From: Ian Hayward [REDACTED]
Sent: 25 November 2021 08:49
To: Amy Myer <Amy.Myer@arun.gov.uk>; Planning.Responses <Planning.Responses@arun.gov.uk>
Cc: Stephen Garrard [REDACTED]
Subject: RE: Resort of the Future, Butlins Bognor Regis - URGENT (BR/234/21/PL)

After review of the submitted documents and latest information presented by the applicants, the Local Highways Authority is satisfied that the proposed rear extension will better facilitate exiting operations on site and will not generate any additional trips to the Butlins site, as such it would not be anticipated that the proposed will result in an unacceptable impact on highway safety or result in 'severe' cumulative impacts on the operation of the highway network, therefore is not contrary to the National Planning Policy Framework (paragraph 111), and that there are no transport grounds to resist the proposal.

Drawn: JD	Approved: JULY 2021
Scale: 1:100 @ A1 PRINT SIZE	
Sheet Description:	
EXTENSION GENERAL ARRANGEMENT LAYOUT PLAN	
Sheet Number: IPL_21_363/12_104	Issue: OG-LPA

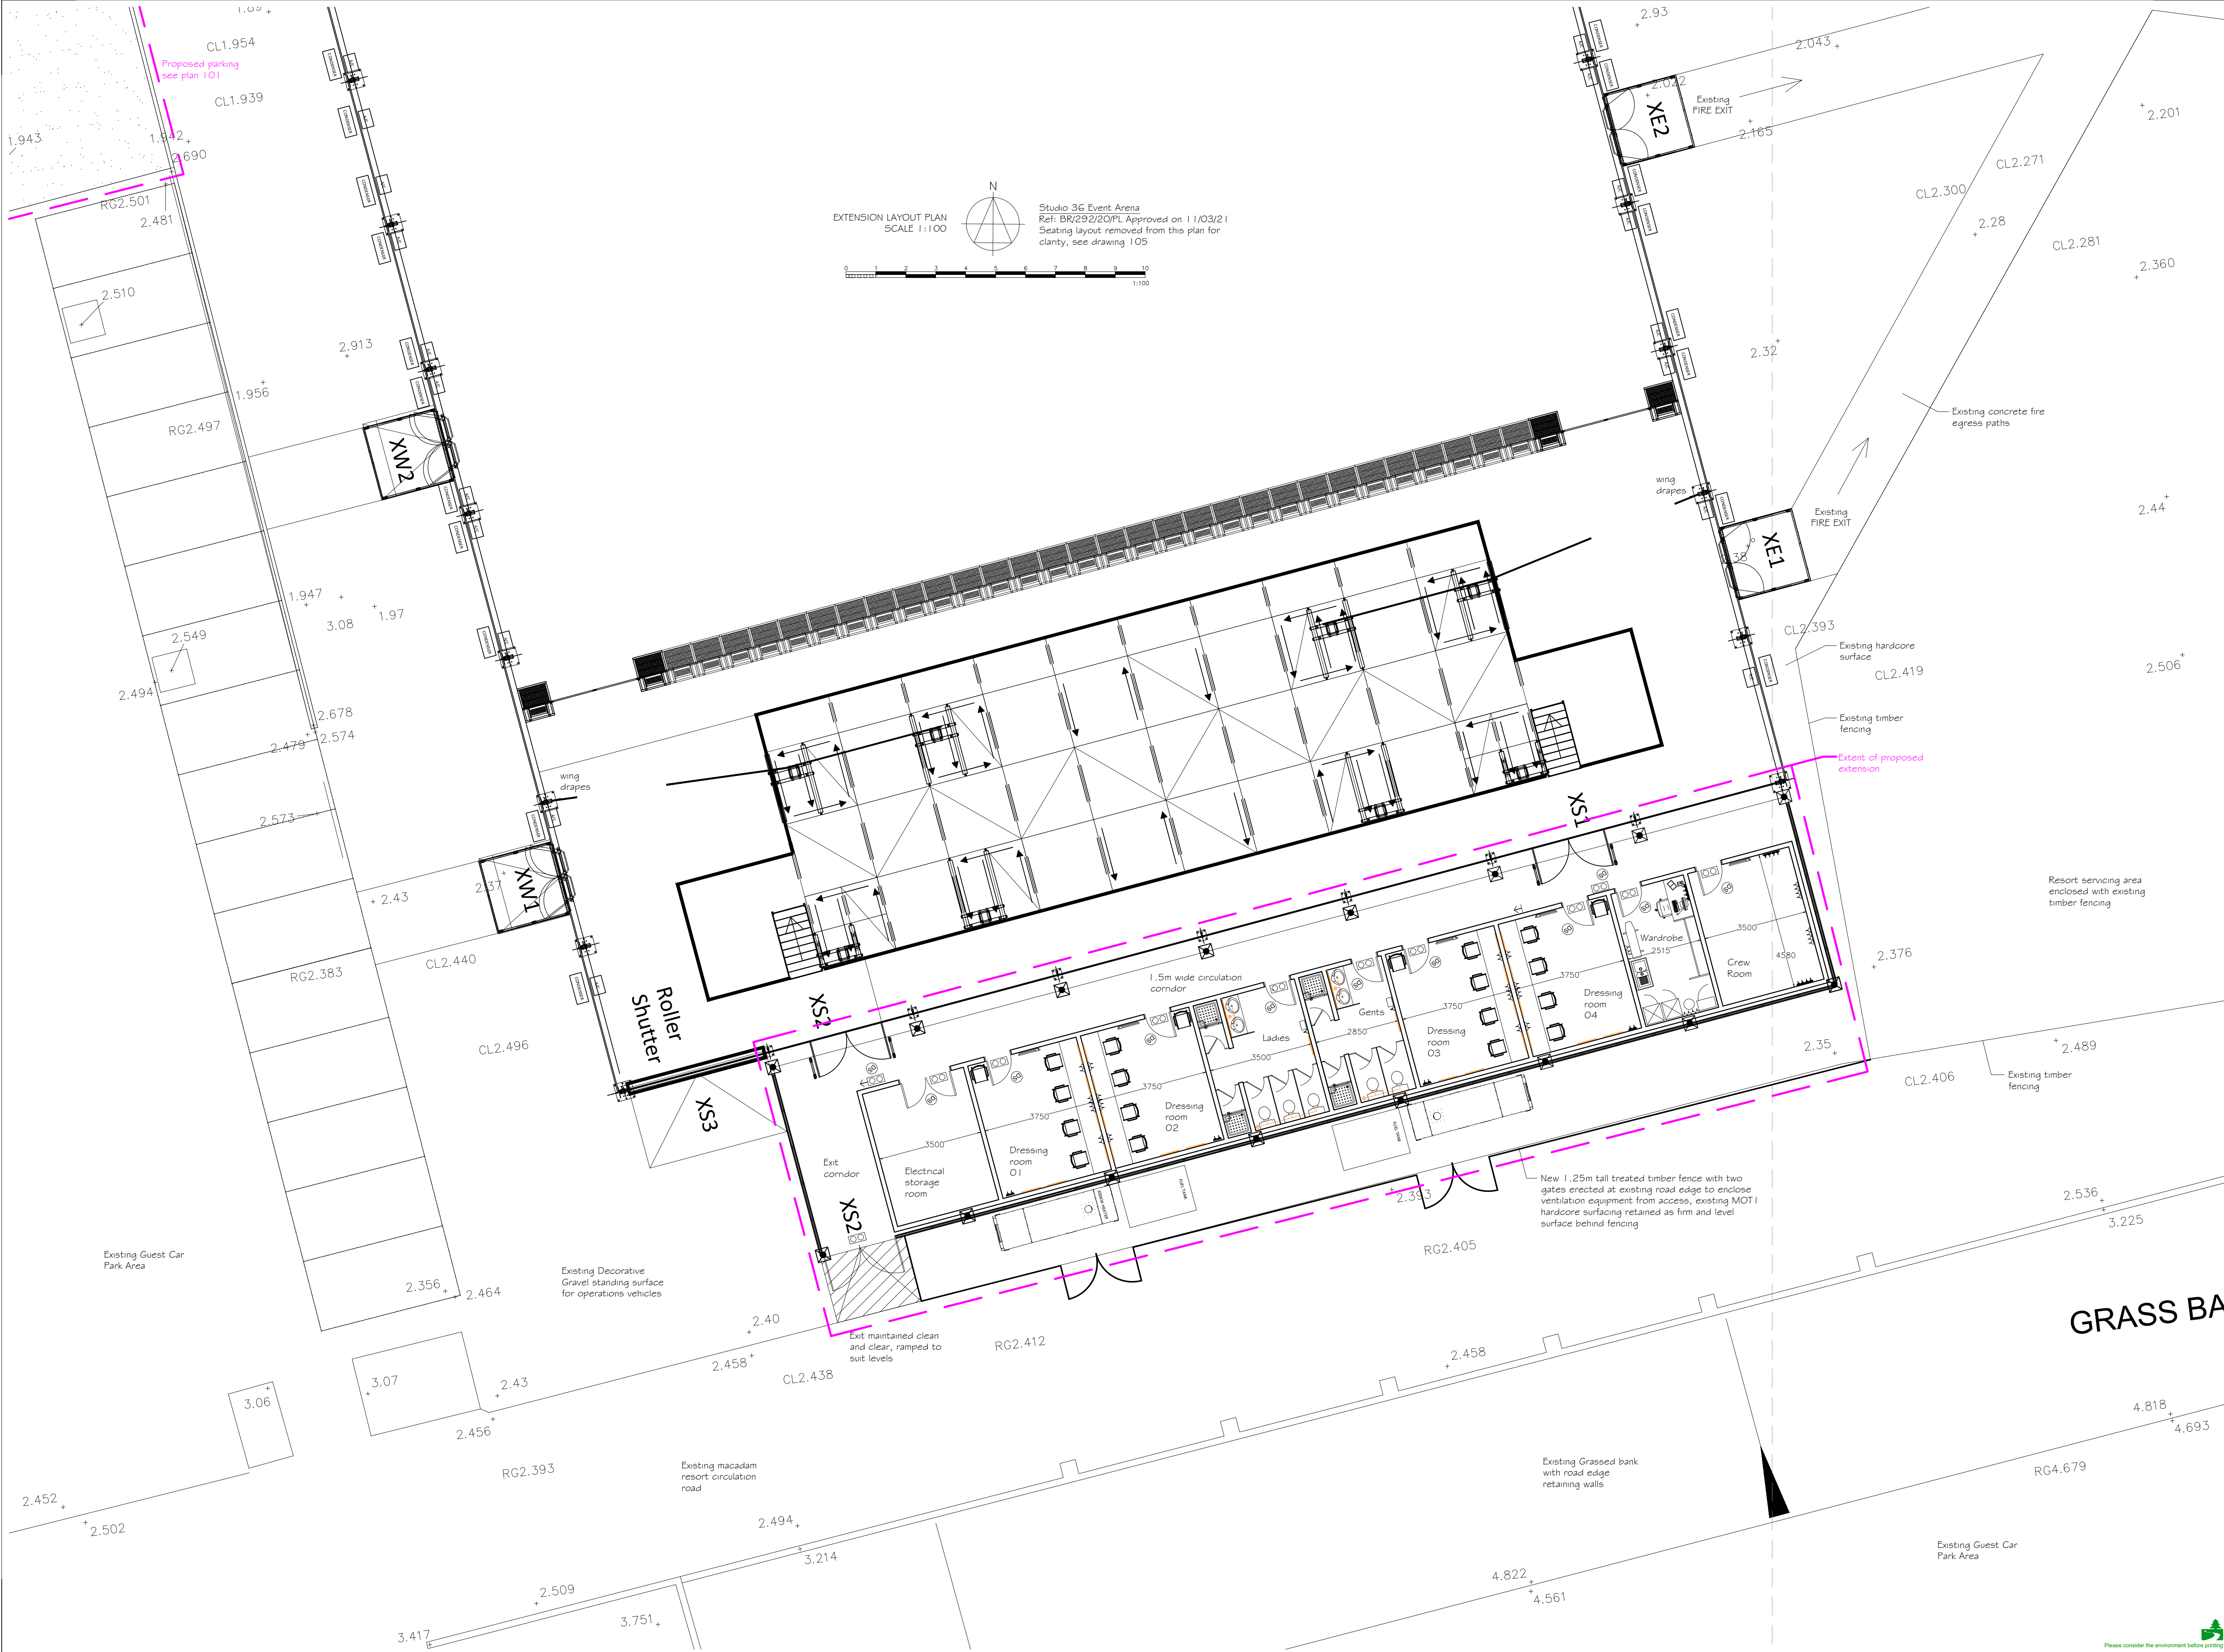
It is understood that the car park works are required to improve upon and increase parking provision on site by 17 spaces (4 parallel spaces, 13 perpendicular). From inspection of this plan the spaces are suitably sized. It is noted that the manoeuvring room between the perpendicular and parallel spaces is 5.5 metres. It is widely accepted within Manual for Streets Guidance that 6.0 metres manoeuvring room is required to access perpendicular spaces in one movement. Based on the plans provided it would be anticipated that these new perpendicular spaces would need to be accessed via a multi-point manoeuvre, which is considered acceptable in slow speed low flow situations such as in car parks like this. The applicant may wish to consider removing the 4 parallel spaces to improve

accessibility of the perpendicular spaces, but this would be for the benefit of amenity rather than anything related to highway safety.
